25 February 2011

RE: Sydney Super yacht Marina

The following submission outlines the significant concerns Leichhardt Council has with regard to elements of the current proposal.

Figure 2.4 Southern and northern elevations of the proposal

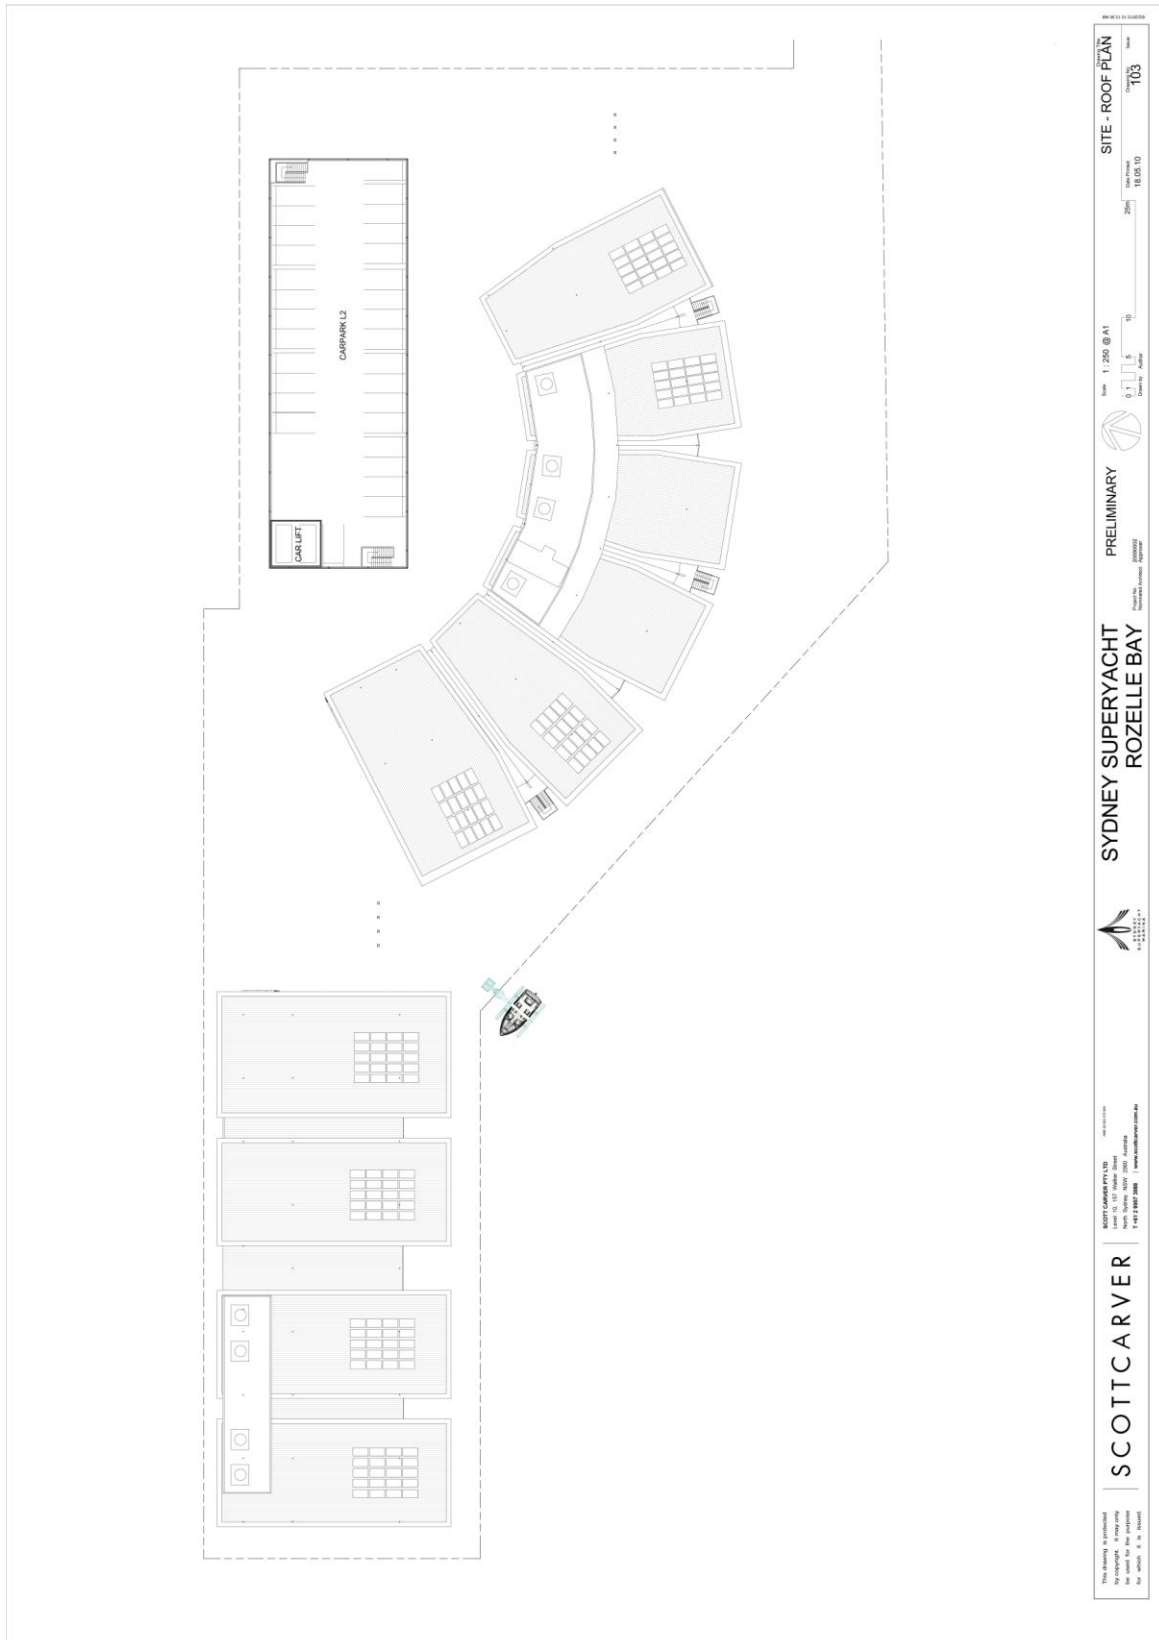
The project description proposes that the lift shaft for the multi level carpark will form a 'visible identification focal point' as justification for what is, essentially a functional requirement of the proposed carpark. Figure 2.4 of the Environmental Assessment document illustrates the south and north elevations and indicates that the lift shaft will be significantly higher than the surrounding buildings. However, no indication is given as to how the lift shaft will make a positive contribution to the establishment of a sense of place, identity and architectural merit nor how it is adequately integrated with the existing or proposed waterfront buildings.
